KIRKLEES METROPOLITAN COUNCIL INVESTMENT & REGENERATION SERVICE

Reference No:	2026/70/90148/W
Site Address:	583, Bradford Road, Fixby, Huddersfield, HD2 2LA
Description:	Variation of condition 2 (plans) on previous permission 2024/93157 for demolition of existing conservatory, partial demolition of existing garage and erection of single storey extensions to front, side and rear, first floor extension to side, raising of ridge height, two dormer windows to the rear roofslope; application of render and associated external works.
Recommending Officer:	Joanna Rednall

DECISION – VARIATION OF CONDITON APPROVED

EAST ELEVATION

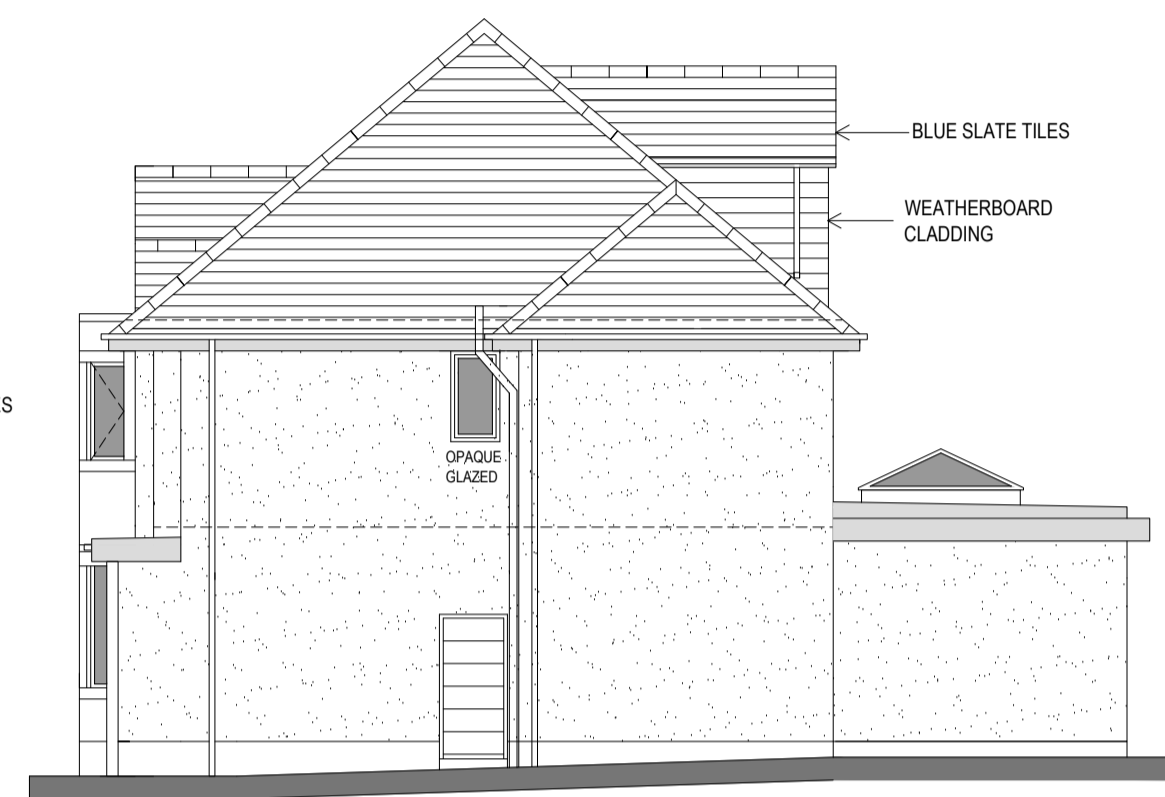
Under the original approval, a lean-to roof was proposed above the garage door on the front elevation. It is now proposed that this element be replaced with a flat-roofed canopy supported by timber posts. The canopy would extend across the elevation to also provide weather protection over the main entrance.

This alteration is modest in scope and would introduce a flat-roof canopy over the front door and a flat-roofed design to the front garage, without changing the garage's existing footprint. The resulting addition would form a small, single-storey element that sits comfortably within the established building line.

Because it does not project beyond the current built form, its visual impact would be limited.

The design is consistent with the more contemporary approach proposed elsewhere on the property and would not detract from the character of the original dwelling. The front of the site is also well screened from wider public viewpoints, and the surrounding street is characterised by dwellings of varied design and form. In this context, the proposal would not appear incongruous or intrusive.

Given its scale, siting, and relationship with the host property, officers consider that this amendment would have been acceptable at full planning application stage. It is therefore regarded as having an acceptable impact on visual amenity and would not harm the character or appearance of the street scene.

SOUTH ELEVATION

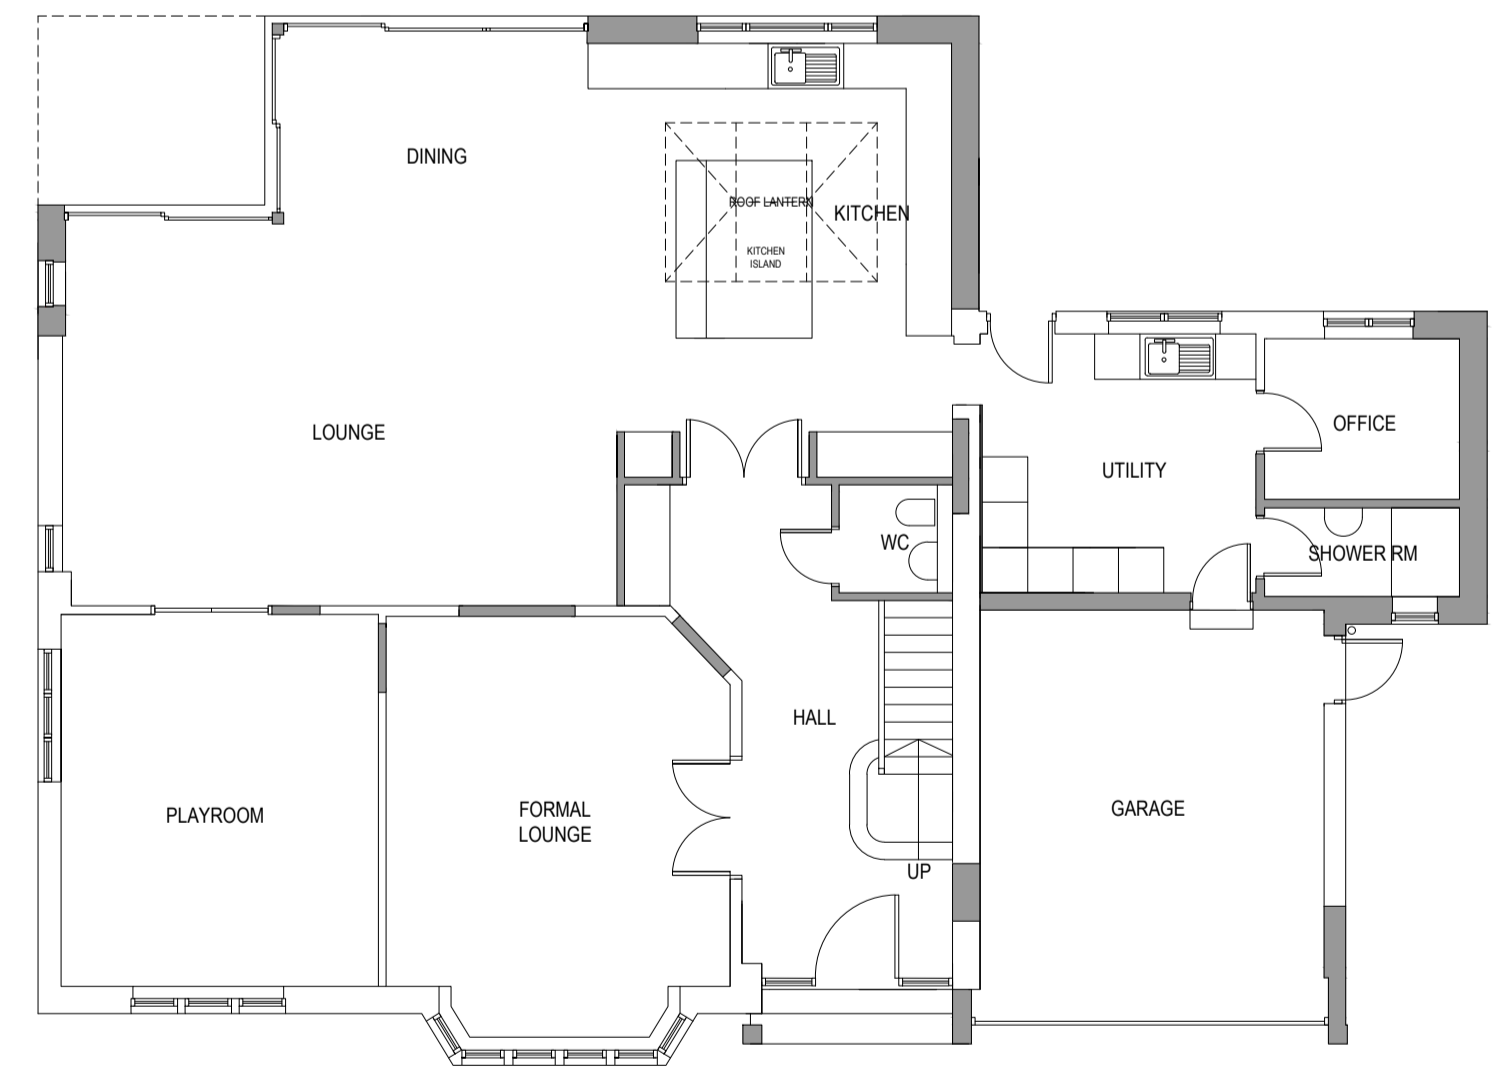
The rear extension is proposed to incorporate a flat roof with a roof lantern in place of the previously approved lean-to roof. As a result, the eaves height would increase from 2.88m to 3.4m; however, the overall maximum height would be reduced from 3.6m to 3.4m. The width of the extension would be reduced in width from 12.5m to 9.5m.

Officers consider that the visual impact of the amendment would be limited, with the proposed changes resulting in only modest alterations to the approved scheme. Although the eaves height would increase, the introduction of a flat-roof design means the overall height would be reduced compared with the previously approved lean-to roof. A roof lantern would be incorporated within the flat roof, but this feature would sit comfortably within the proposed form and would not materially increase the building's massing. The overall size, scale and footprint would remain broadly consistent with the approved development and would continue to comply with the design principles set out in the Council's Extensions SPD. Existing walling materials would be retained, ensuring continuity with the host dwelling.

While a flat roof can, in some circumstances, be considered less sympathetic to the character of a traditional dwelling, in this case the design is positioned to the rear of the property, where public views are limited. The change would therefore have minimal effect on the streetscene or wider visual amenity. Given the reduced overall height, the limited visibility, and the consistency with the previously approved scale, officers consider that the amended design sought under this application would have been acceptable at full application stage. Therefore, taking the above into account, the proposal is not regarded as giving rise to any visual harm, and it is considered to respect the character and appearance of both the host property and the surrounding area.

ATTIC FLOOR PLAN

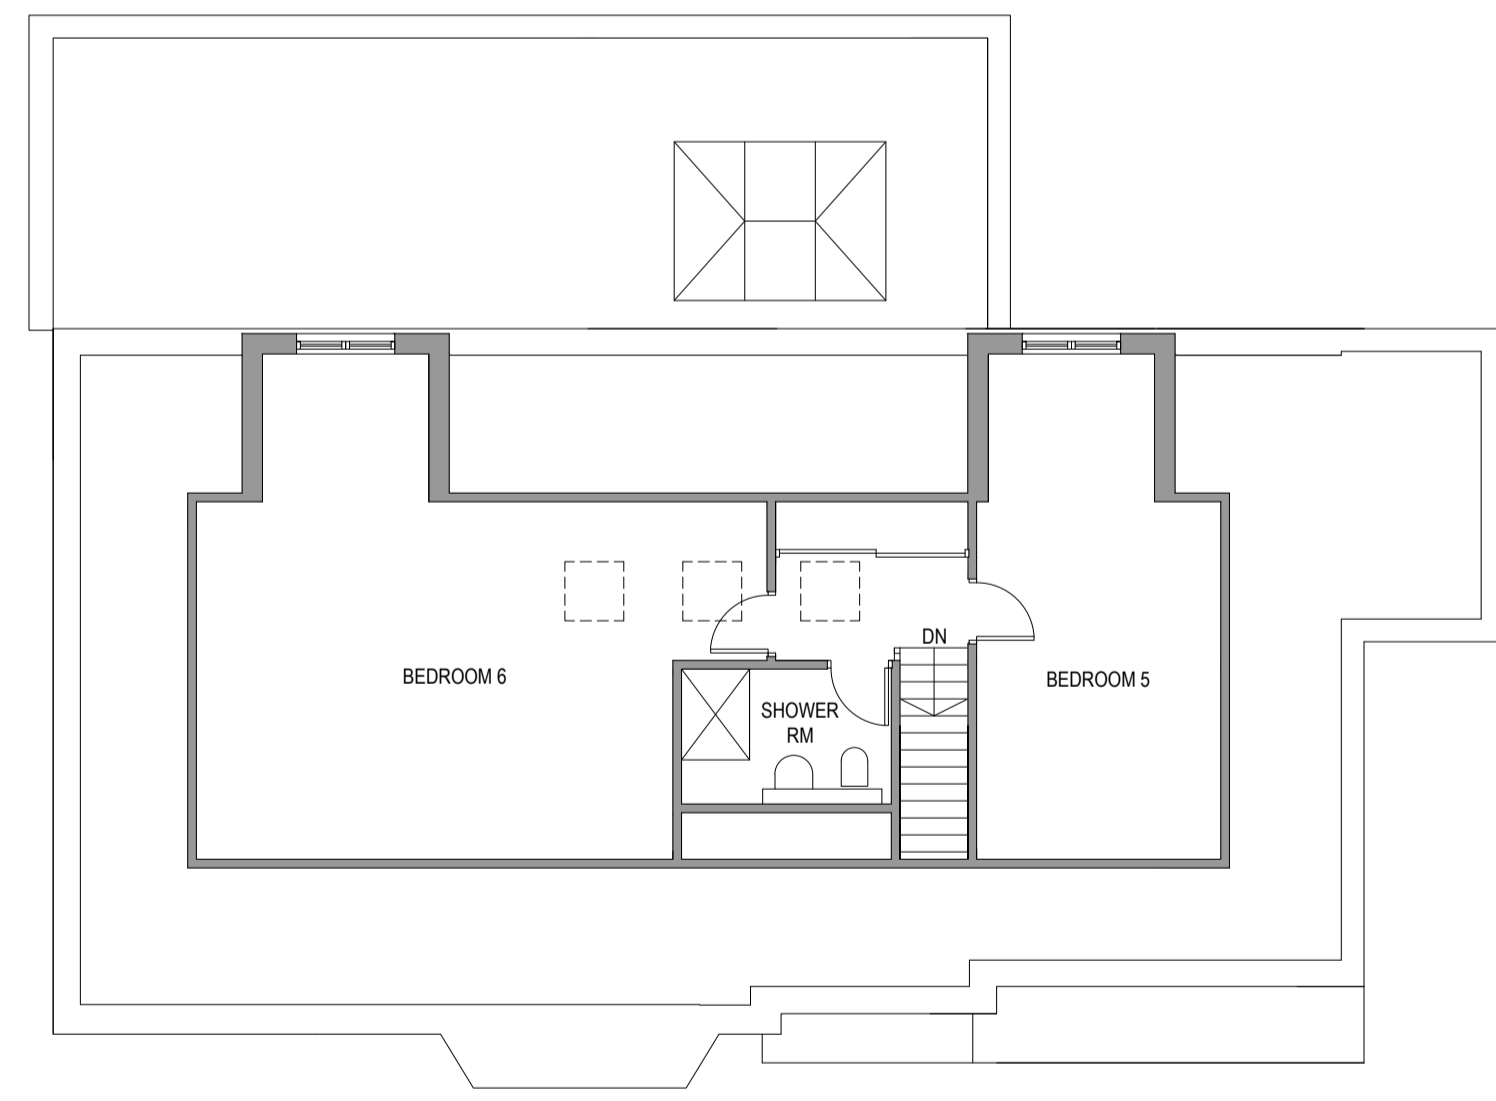
The approved drawings showed roof pitches of 40 degrees on the north-south axis and 35 degrees on the east-west axis. Due to spatial constraints within the attic, it is now proposed that a consistent roof pitch of 40 degrees be used throughout. The ridge height of the host property would be increased by 0.7m. This would not appear overbearing in scale or result in a form which would appear at odds with the host.

It is proposed that the rear dormer be finished in dark weatherboard cladding rather than the previously approved render. These materials would differ from those on the host property, but their use is considered acceptable given the specific context of the proposal. The dormers are proposed to the rear of the dwelling, where visibility from public vantage points is limited. As a result, the change in material would not materially affect the character of the streetscene or the wider area. This conclusion is drawn given the use of blue slate tiles to the roof and it is considered the proposed materials to the dormer cheeks and face would suitably integrate with the design of the dwelling.

Within the rear roofscape, weatherboard cladding would sit more discreetly than a cream-coloured render, reducing contrast and helping the extension blend more effectively with the surrounding roof plane. The choice of material therefore softens the visual impact of the addition and avoids introducing a stark or visually dominant element.
